**KIRKLEES COUNCIL
TOWN AND COUNTRY PLANNING ACT 1990
HIGHWAYS DEVELOPMENT MANAGEMENT**

PLANNING REF 2018/62/90283/W0/AM
CATEGORY Other

PROPOSAL ERECTION OF SINGLE STOREY
AND REAR EXTENSIONS AND
DEMOLITION OF EXISTING SINGLE
STOREY EXTENSION(WITHIN A
CONSERVATION AREA)

LOCATION 1 MOUNT PLEASANT
STANLEY LANE
GOLCAR
HUDDERSFIELD
HD7 4AG

Revisions:
 A: Boot room adjusted and parking re-arranged, March 18

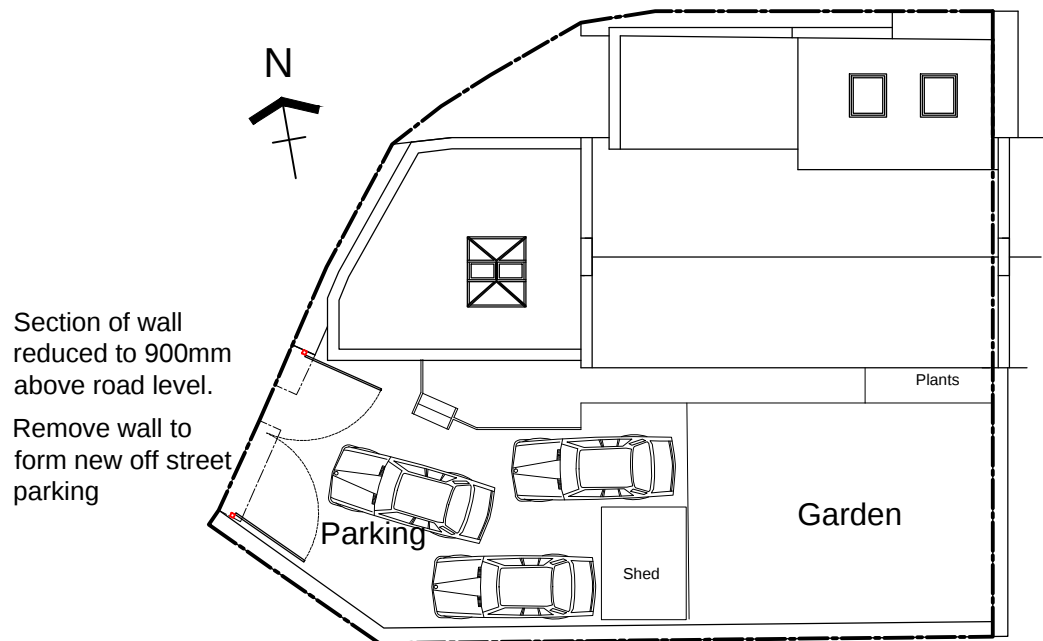
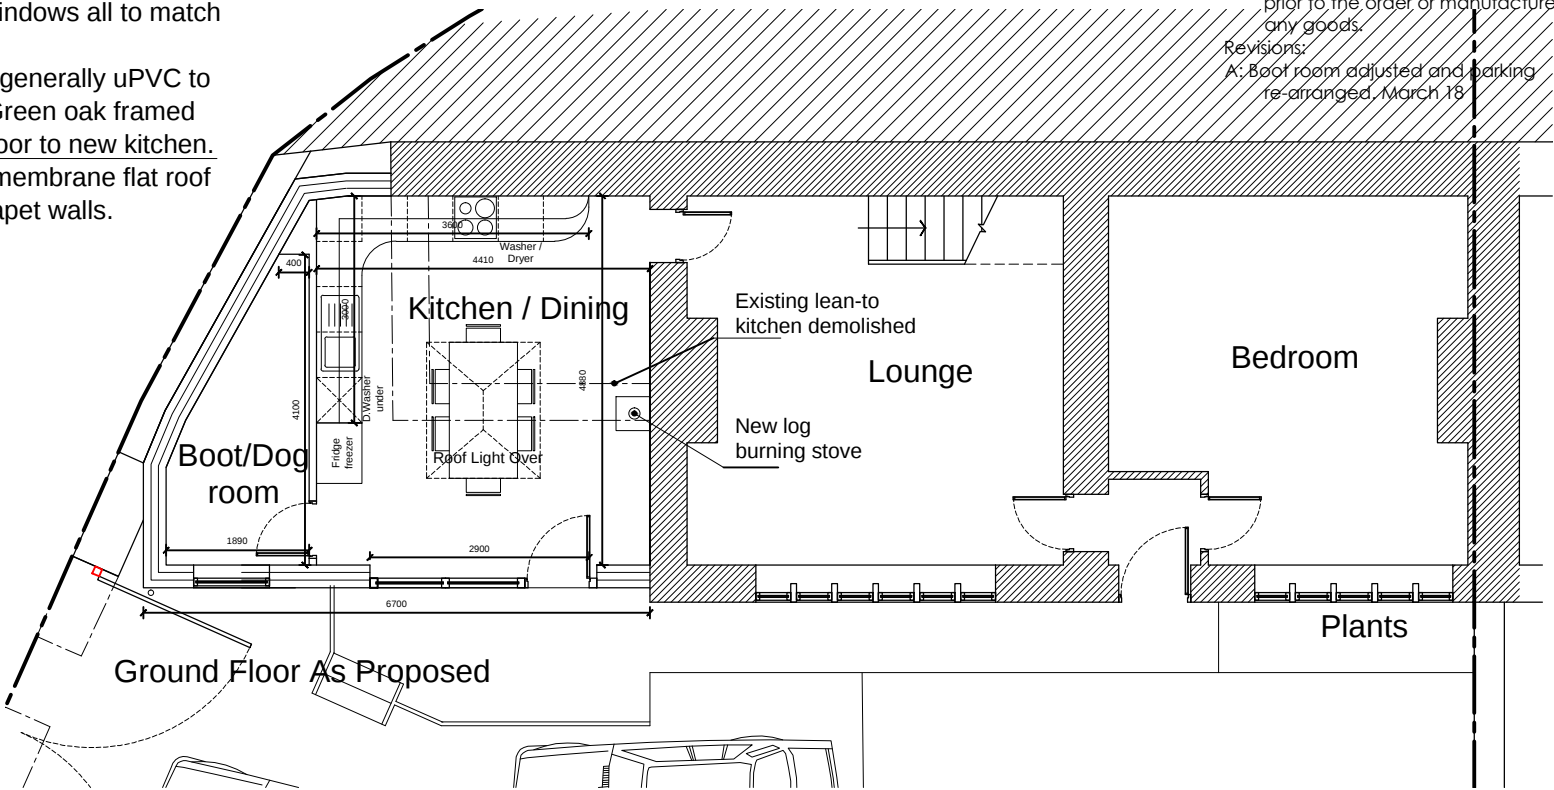
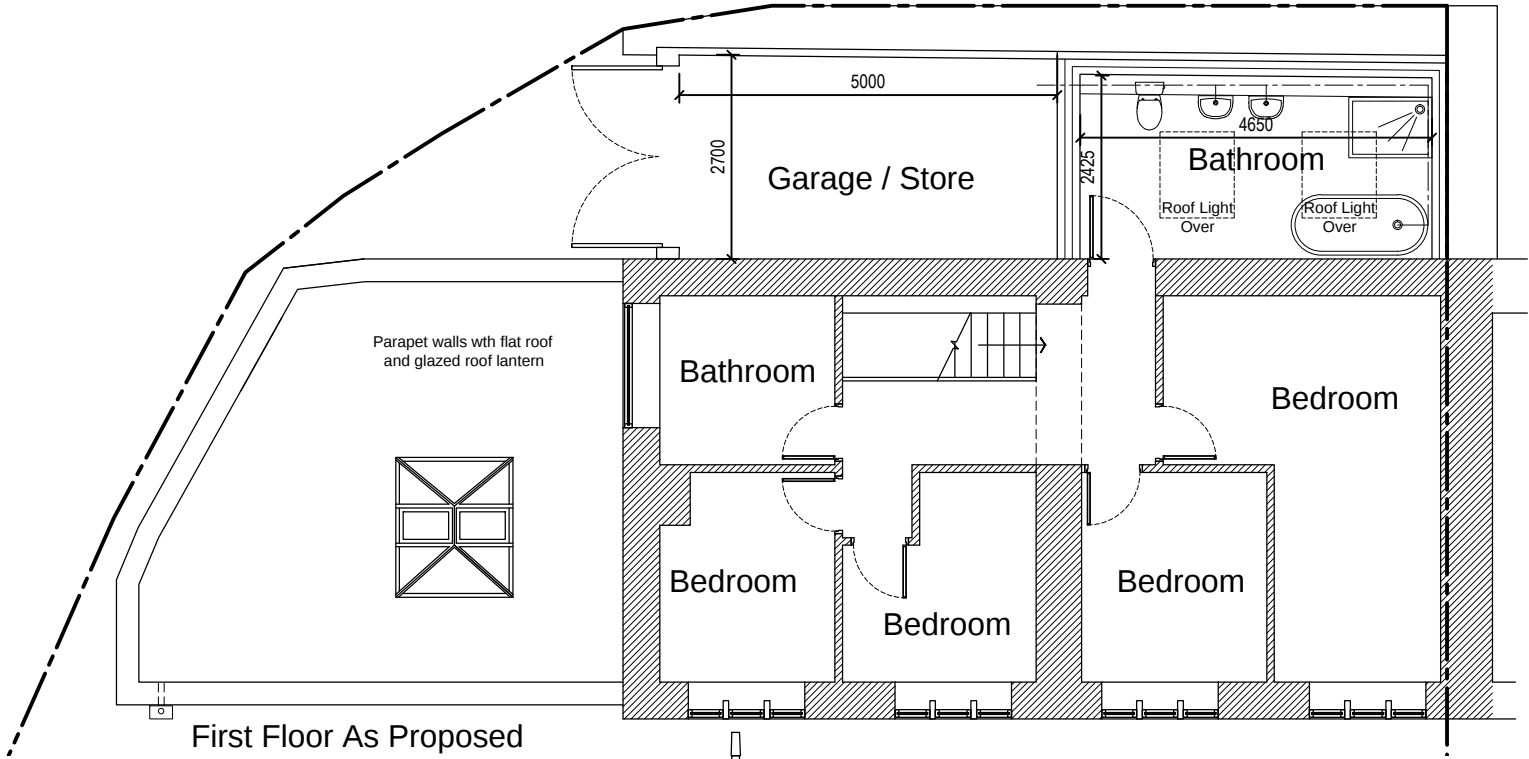
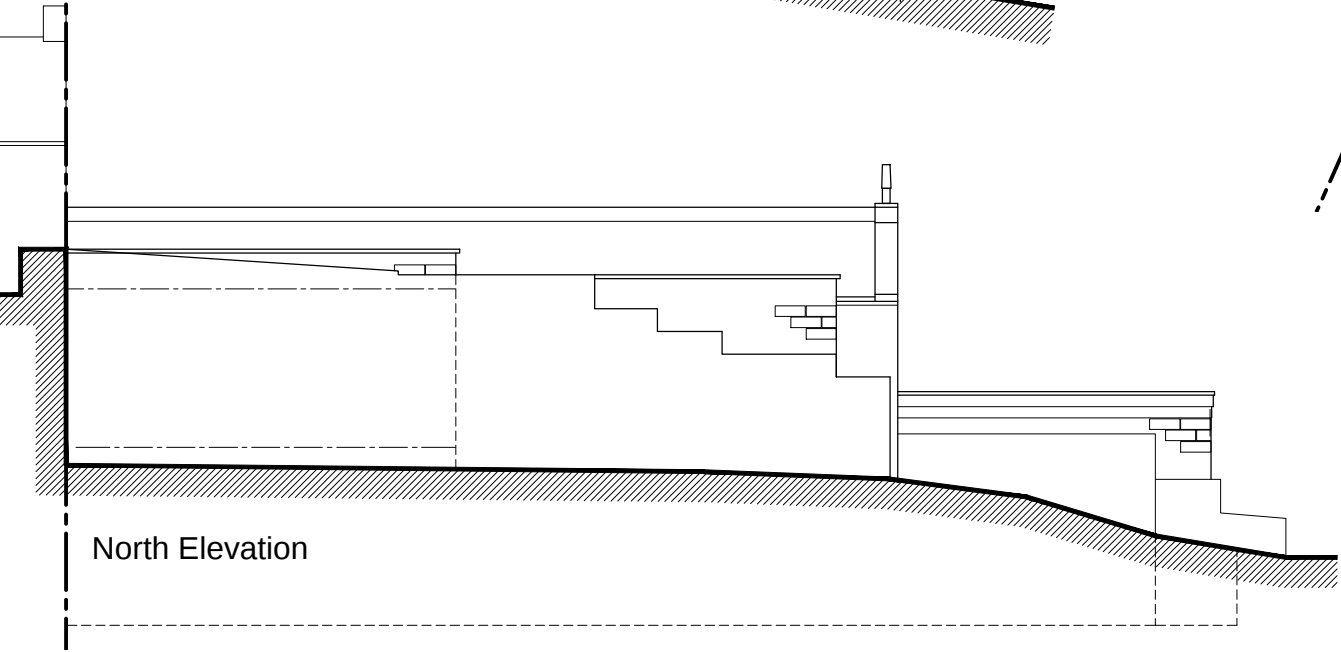
The supplementary information shows that the proposals meet Kirklees parking standards of 3 off road parking spaces for this size and type of development.

Dwg ref: 1MP/P03 rev a : Scale 1:500 @ A3 : February 2018

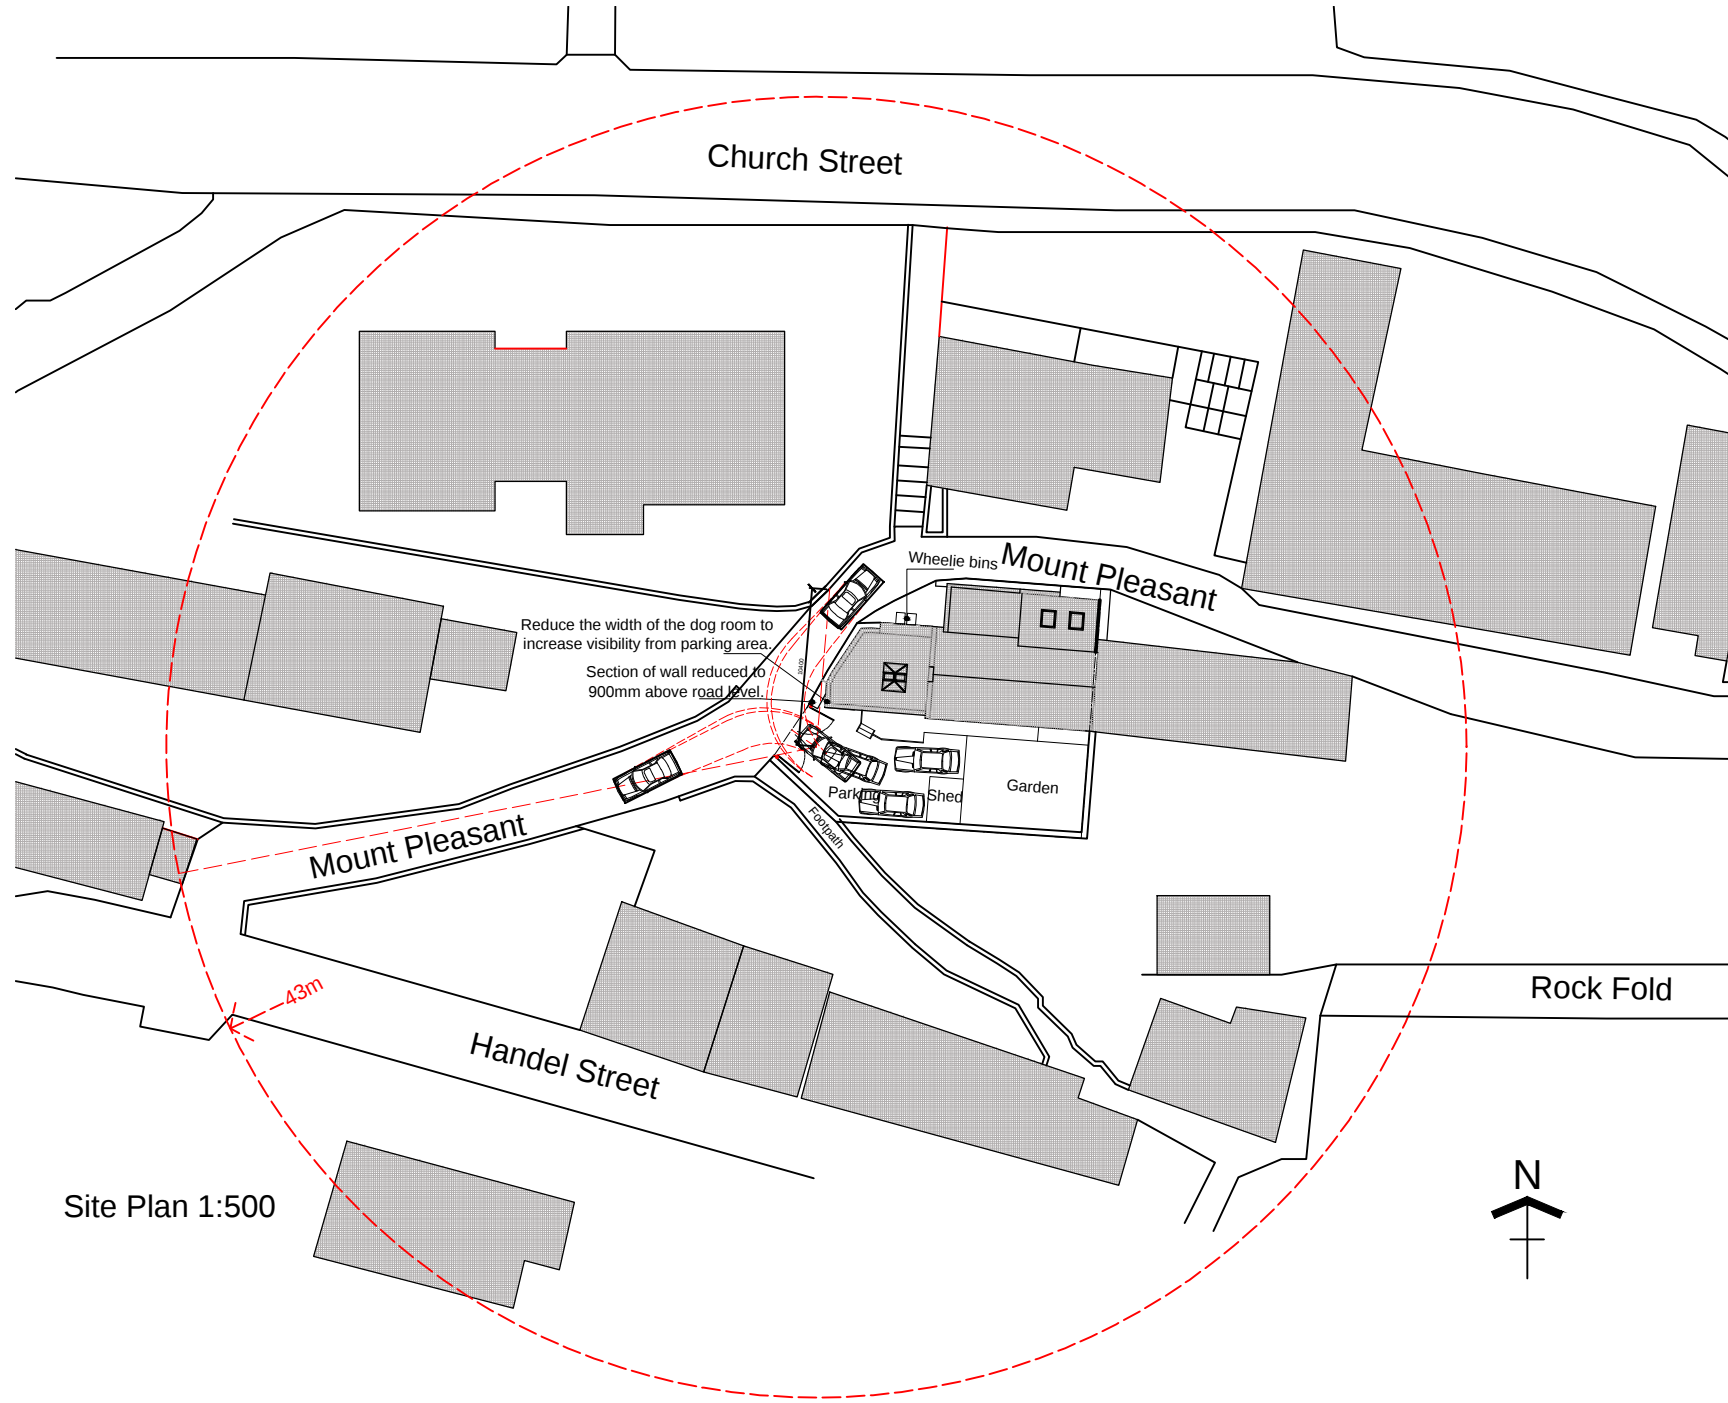
A full visibility splay of 2.4 x 42m is obtainable to the left of the new access. With the amendments to the design of the dwelling the visibility splay to the right still doesn't reach standards, however given the road conditions on Stanley Lane I wouldn't expect vehicles to be able to reach the posted road speed and to be driving in a cautious manner, therefore a relaxation of the standards is suitable and

would not impact upon highway safety. The swept path analysis shows that a car can access/egress the parking area safely, with egress to be made in forward gear as shown on the plans. I consider that the new access is acceptable on highways grounds.

The waste collection details supplied in the supplementary information are acceptable and the alternative location gives the option to secure the gates and still allow for refuse/recycling collection if required without obstructing the safe operation of the highway.

With this I consider the proposals as amended are acceptable on highways grounds but I would like the following note and condition relating to parking space surfacing adding to any planning permissions that may be granted.

Prior to the development being brought into use, the approved vehicle parking areas shall be surfaced and drained in accordance with the Communities and Local Government; and Environment Agencies 'Guidance on the permeable surfacing of front gardens (parking areas)' published 13th May 2009 (ISBN 9781409804864) as amended or superseded; and thereafter retained throughout the lifetime of the development.
